V3_Drainage Letter_COMMENTS.pdf Markup Summary

Letter Type - Drainage Report

5935 Templeton Gap Road

Office Renovation

SITE MAP / DRAINAGE PLAN

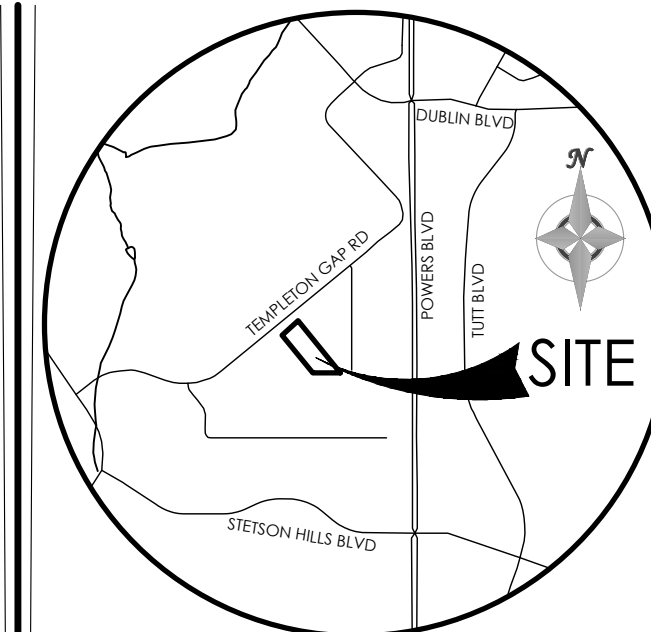
The drainage maps should compare existing to proposed conditions.

Typical drainage maps are required with existing (historical) vs. proposed (current) with basins and design points and flow summaries.

A full FDR is not required for this application but standard drainage report elements must still be included in the report and maps.

Although there are no changes to the drainage patterns proposed, the existing condition of the site was never approved or analyzed.
